From: MarkHobbs [REDACTED]
Sent: 07 May 2021 11:46
To: sarah.burrows@arun.gov.uk
Cc: 'Glynn Curtis' [REDACTED] Simon Davis <Simon.Davis@arun.gov.uk>
Subject: P/38/21/PL - Little Sefter Planning Application - Proposed Drainage Condition

Further to our conversation this morning regarding the LPA surface water consultation we respond as follows:

PROJECT	BARN EXTENSION BARFOOTS - LITTLE SEFTER PAGHAM RD, BOGNOR REGIS WEST SUSSEX, PO20 1LN				
DRAWING	DRAFT PROPOSED EXTERNAL LEVELS & CONSTRUCTION FINISHES				
SCALE	PTN No	FC2846/03	REV	B	
Varies	DATE	JAN 20	INITIAL	MH	CHKD

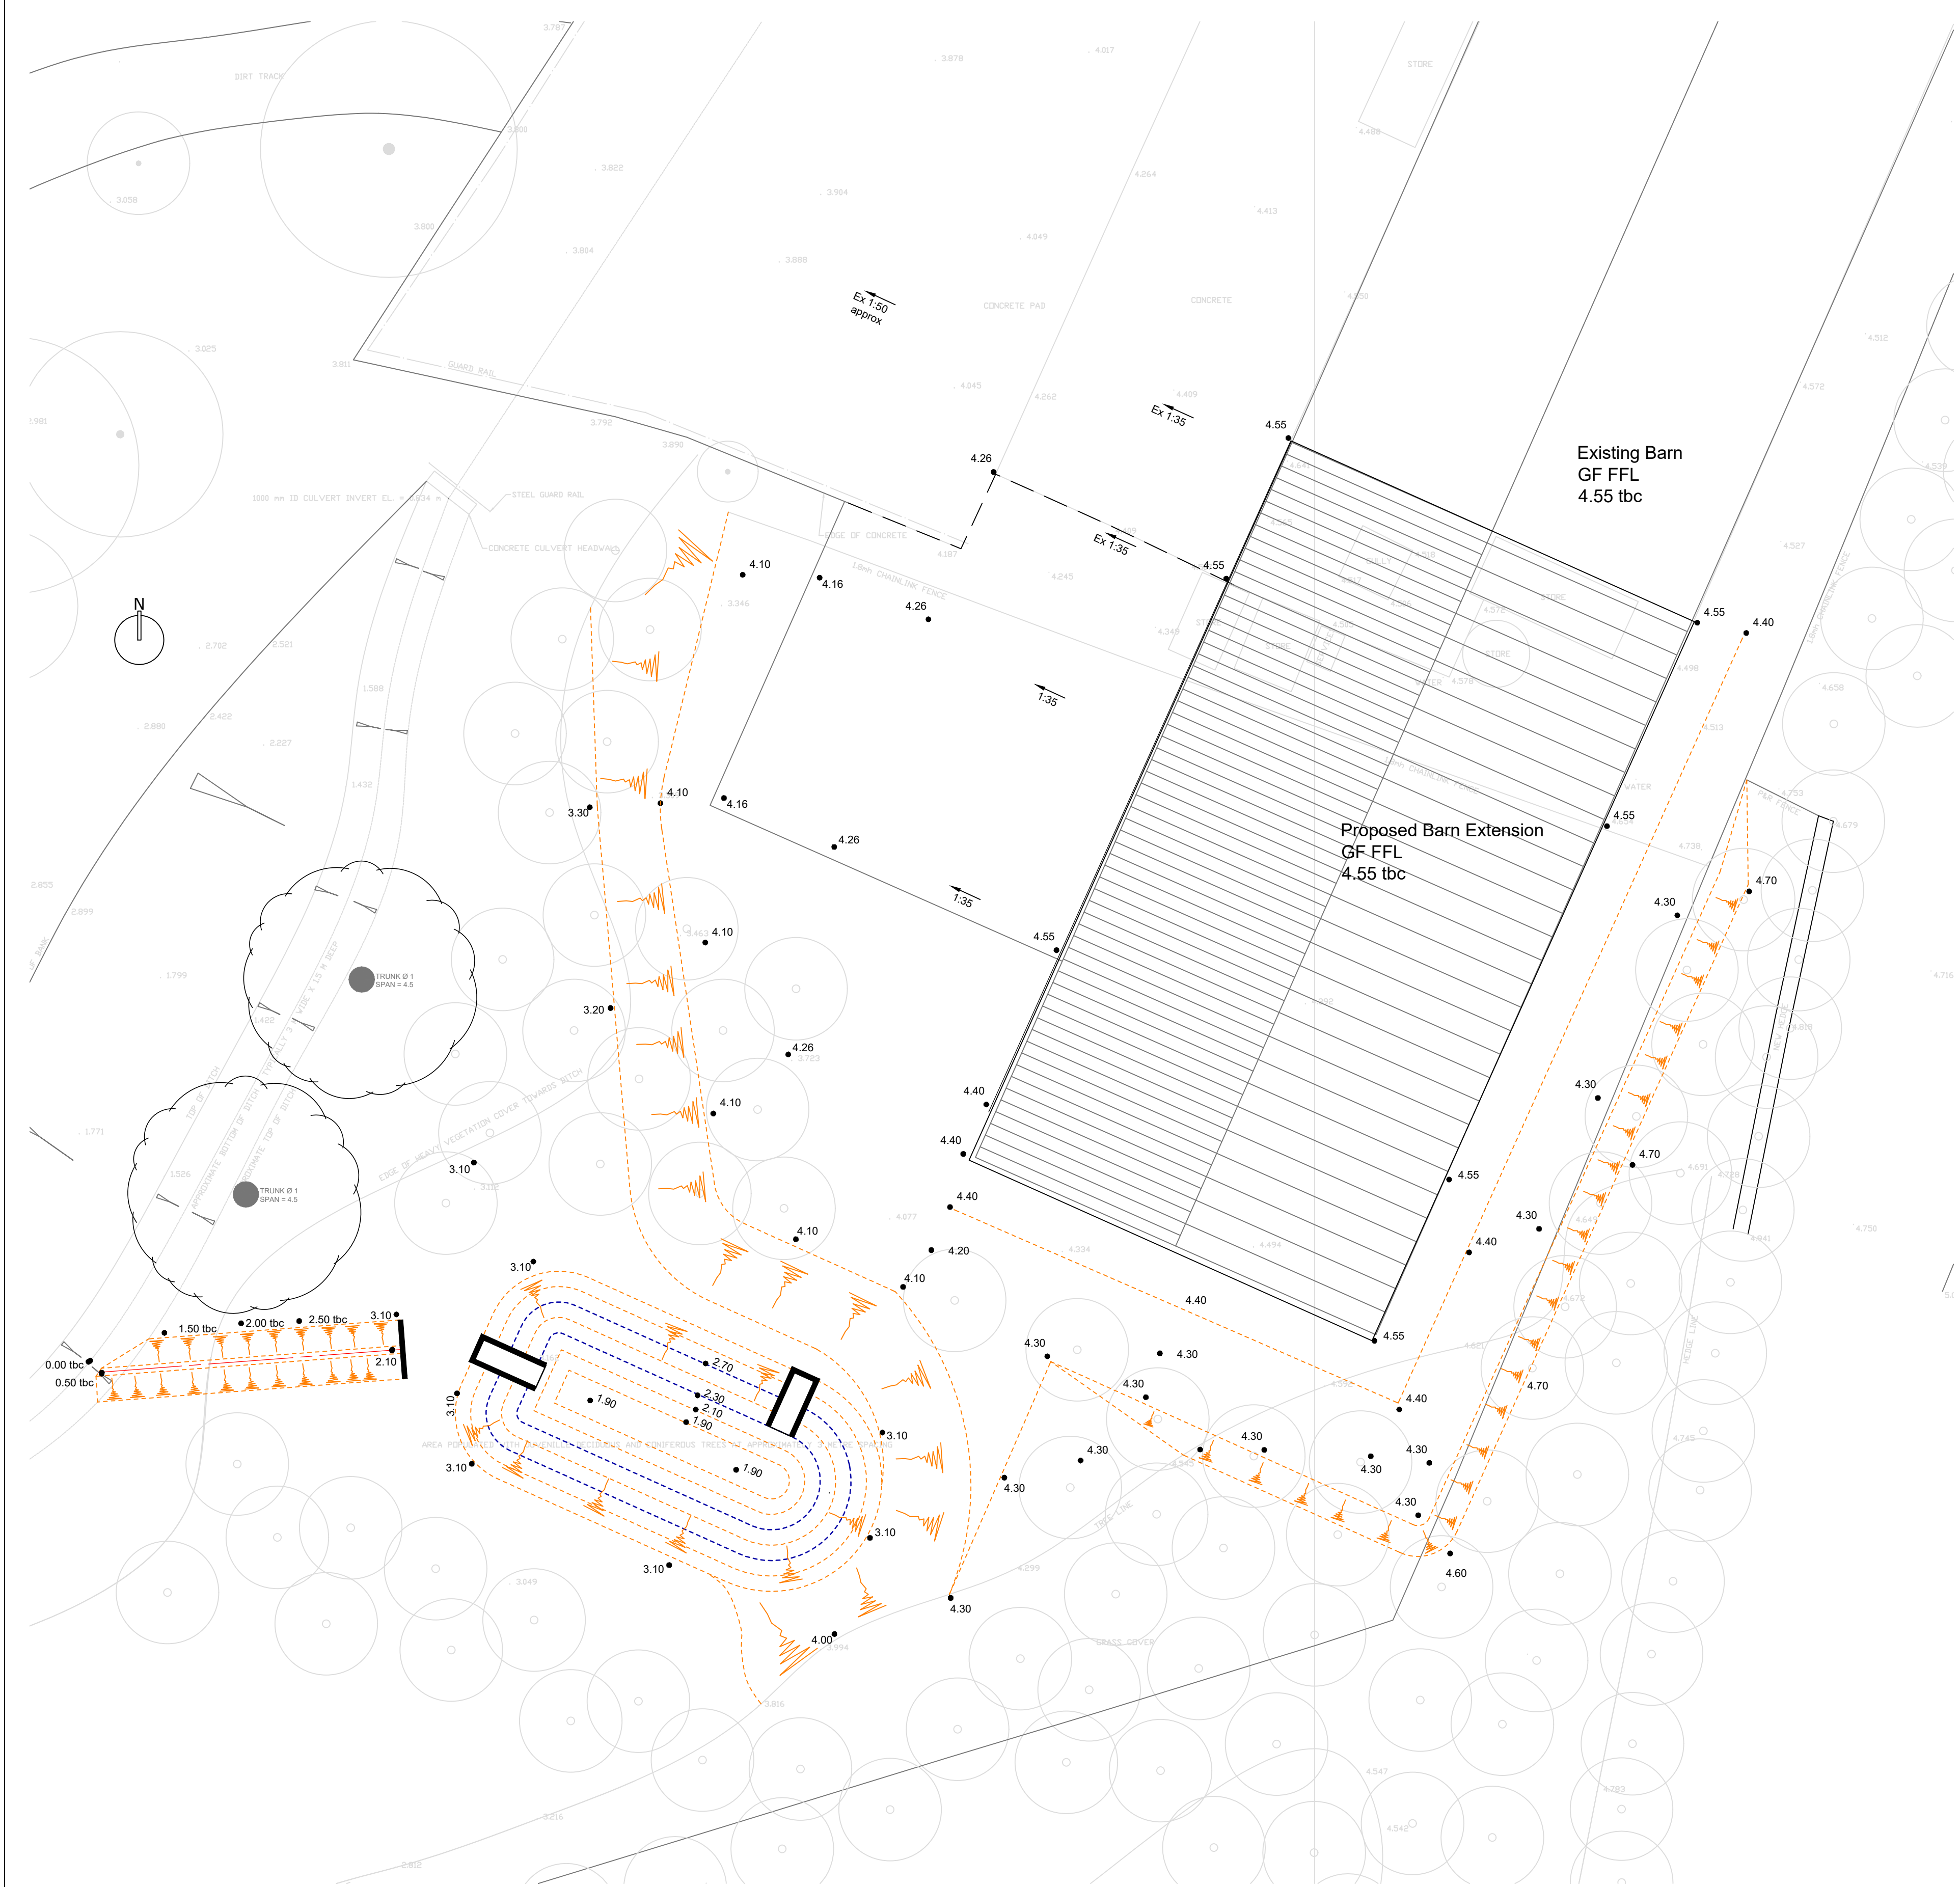
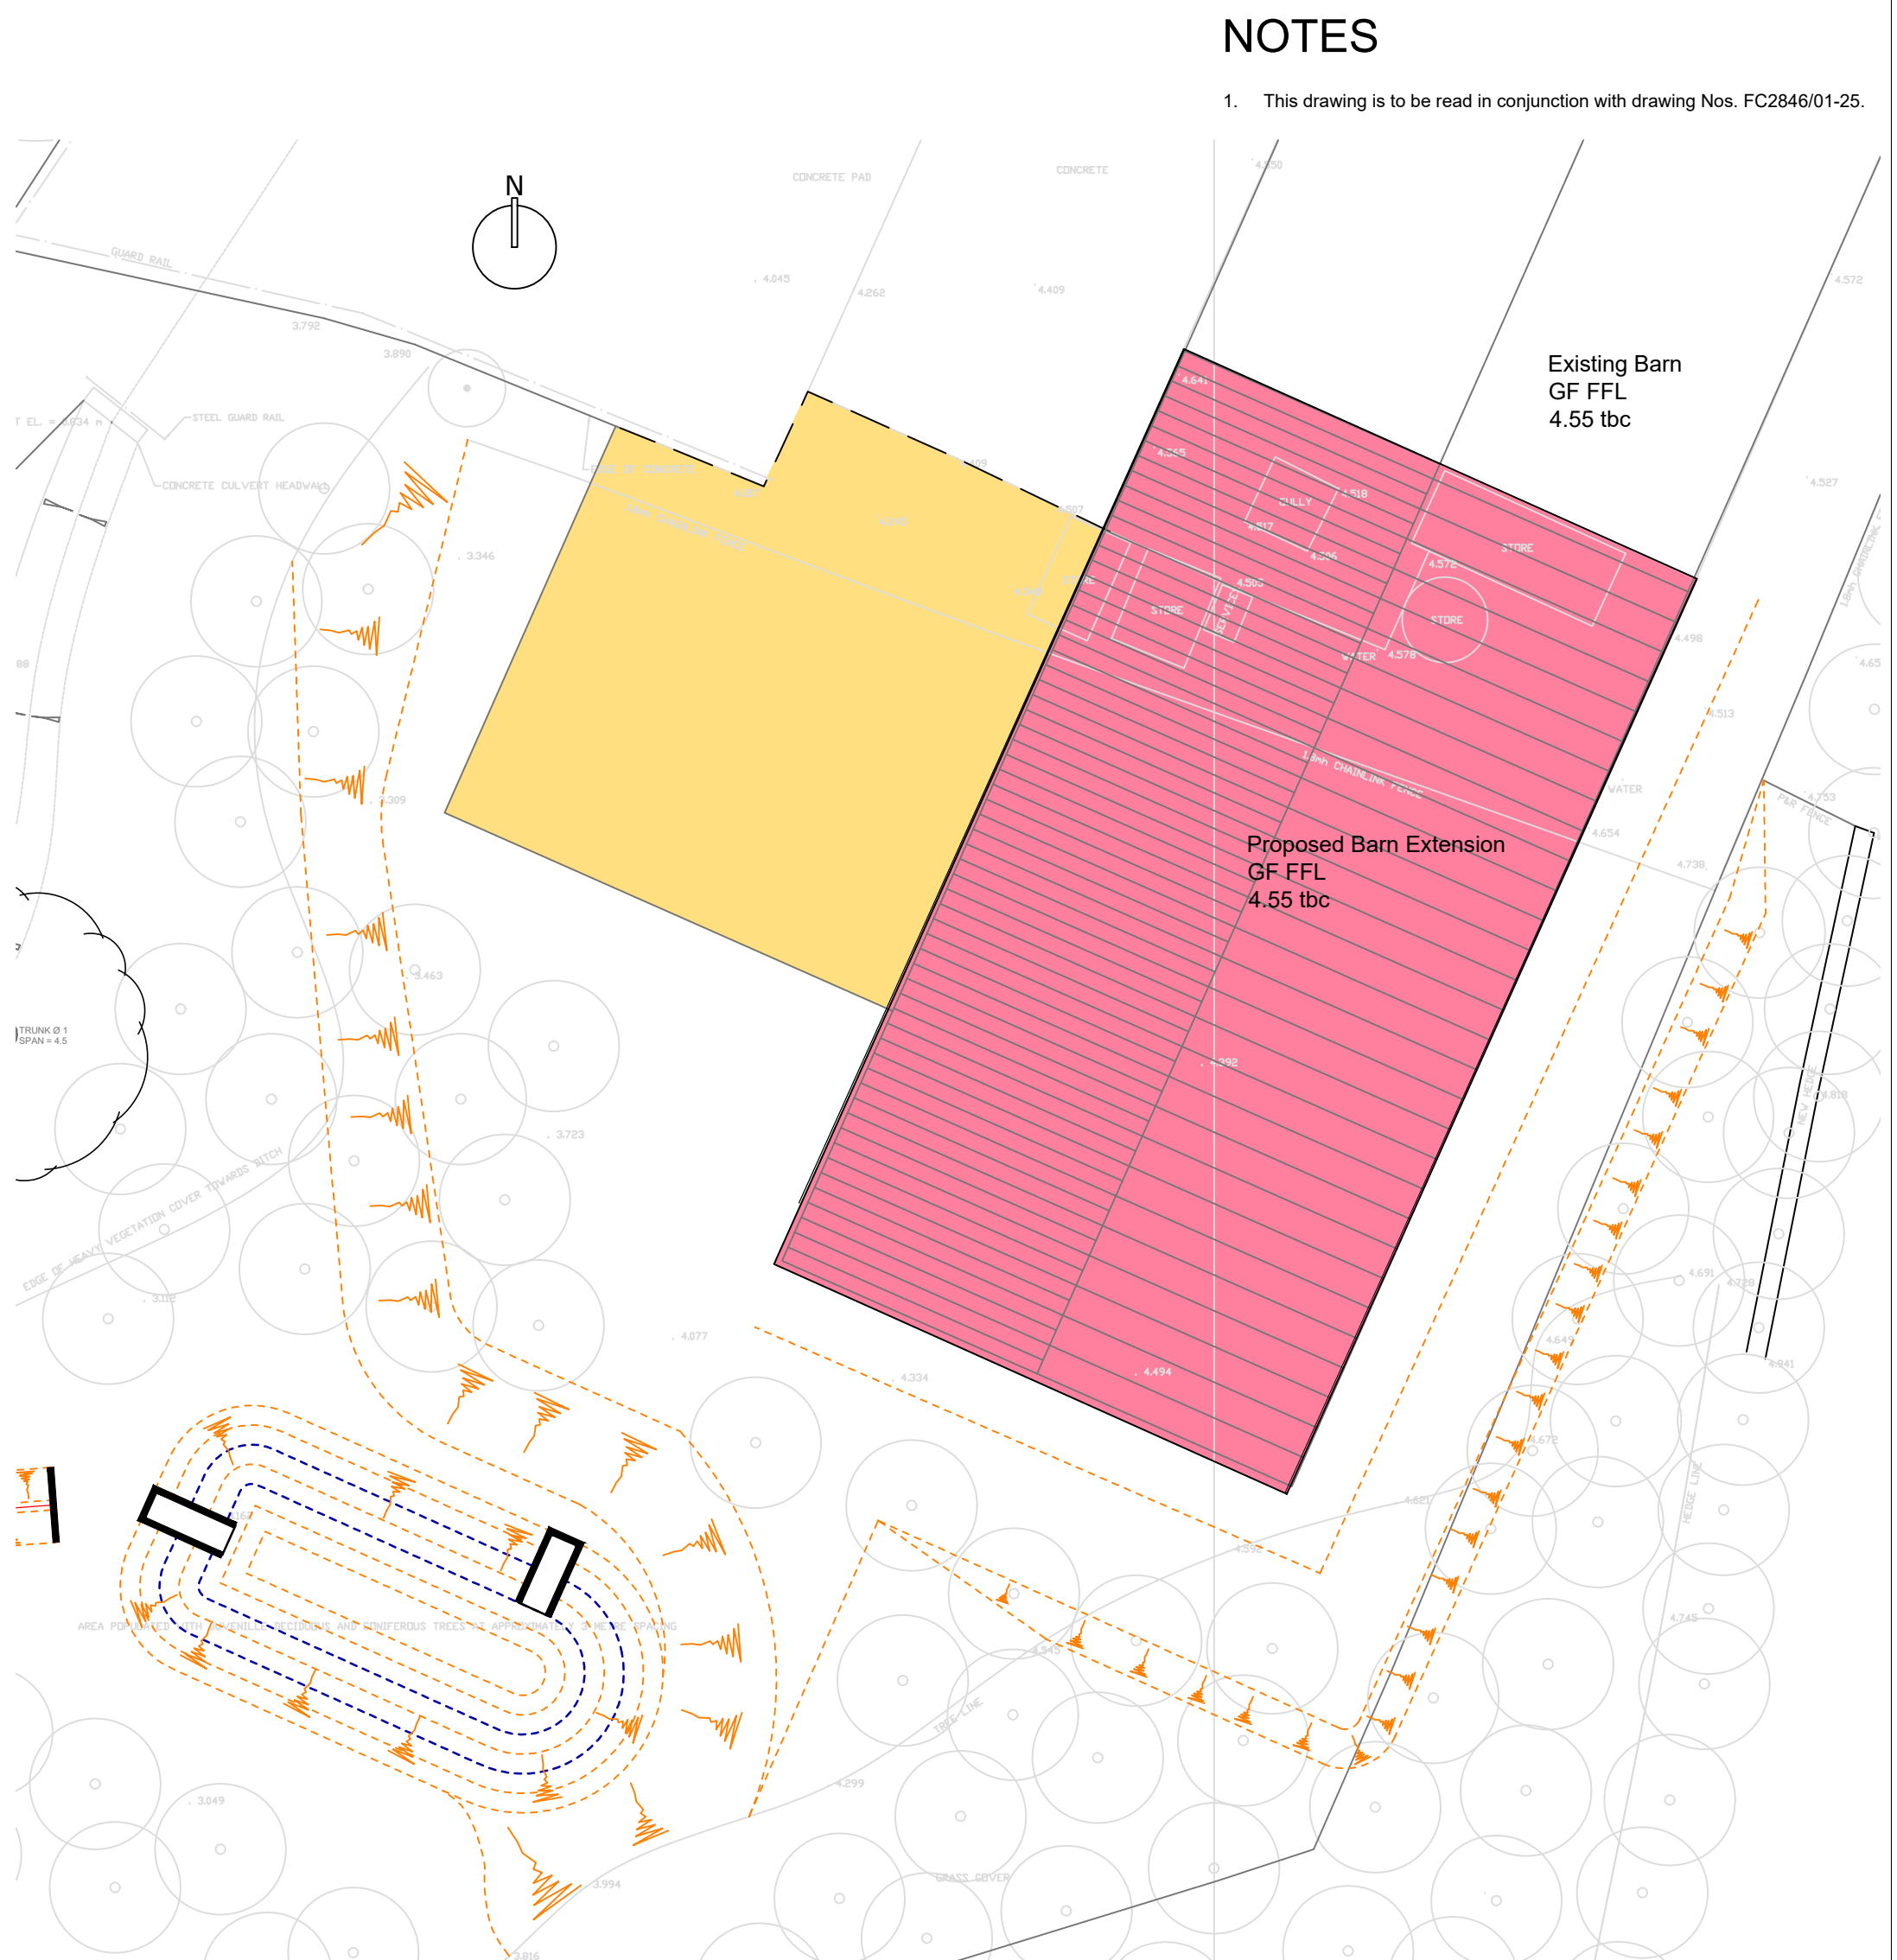
- The proposed restricted run off from the development has been set at 5l/s in line with DEFRA recommendations as the default minimum flow rate to avoid overburdensome/frequent blockages occurring.

- We appreciate that the site is small and that the greenfield site runoff rate would be lower than 5l/s, tending to 2l/s.
 - However, proposing a flow control restricting flows to 2l/s would in our opinion lead to a significant increase of blockage risk as the flow control will have a smaller orifice.

- Given that the system proposes a storage pond/swale with a wetted portion below the outlet level, and the feature is not tanked, then some infiltration and spare capacity will be present.

- However, our concern is that the feature is a natural feature within a wooded glade, and thus twigs/leaves/vegetation will be regular sources of debris that could cause a blockage of the flow control. Obviously we can provide screening to the outlet headwall from the pond/swale, though that will only move the blockage upstream.

- We would suggest that a 5l/s flow control would have an adequate orifice to cater for the majority of blockage issues without overburdensome maintenance regime.

- It is suggested that a 2l/s flow control would only be prudent within a sealed/closed system such as outlet from sealed tanks/porous paving systems where the risk of blockage through debris is extremely unlikely.

- We trust that after reconsidering the system proposed and the wider natural benefits that it offers that you can agree to the proposed 5l/s restricted discharge rate in this instance.
